Re: Project No. HA-3339-RAJ/JKB  
FID No. 921084  
Springs of Ballentine (The)  
New 50 Bed Assisted Living Facility  
Fuquay Varina (Harnett)

The referenced project was inspected on October 17, 2024, by Rita Jones, Keith Blackwell, Jerry Rivera and Don Schlagle. This project cannot be approved until the following deficiency has been corrected:

JOB #: 5705900.
JOB NAME: *** SENTER'S KITCHEN HOOD.

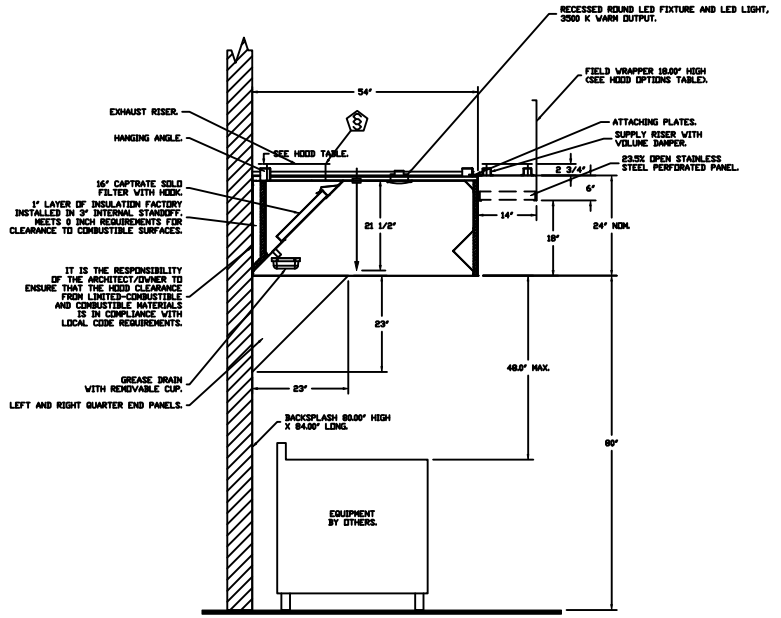
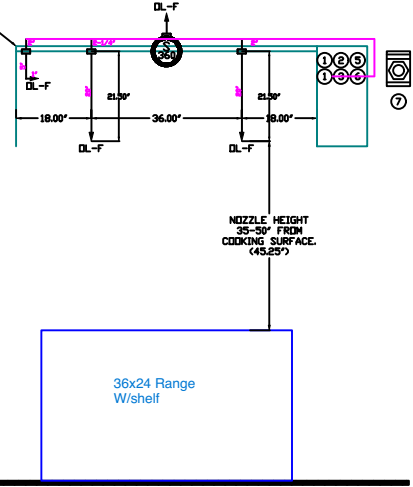
14. Provide an access door in the return duct of AHU-10 for the duct detector.
15. Provide verification from the local Fire Marshal for their approval of the kitchen hood which falls short of the required 6-inch overhang for the appliances under the hood.
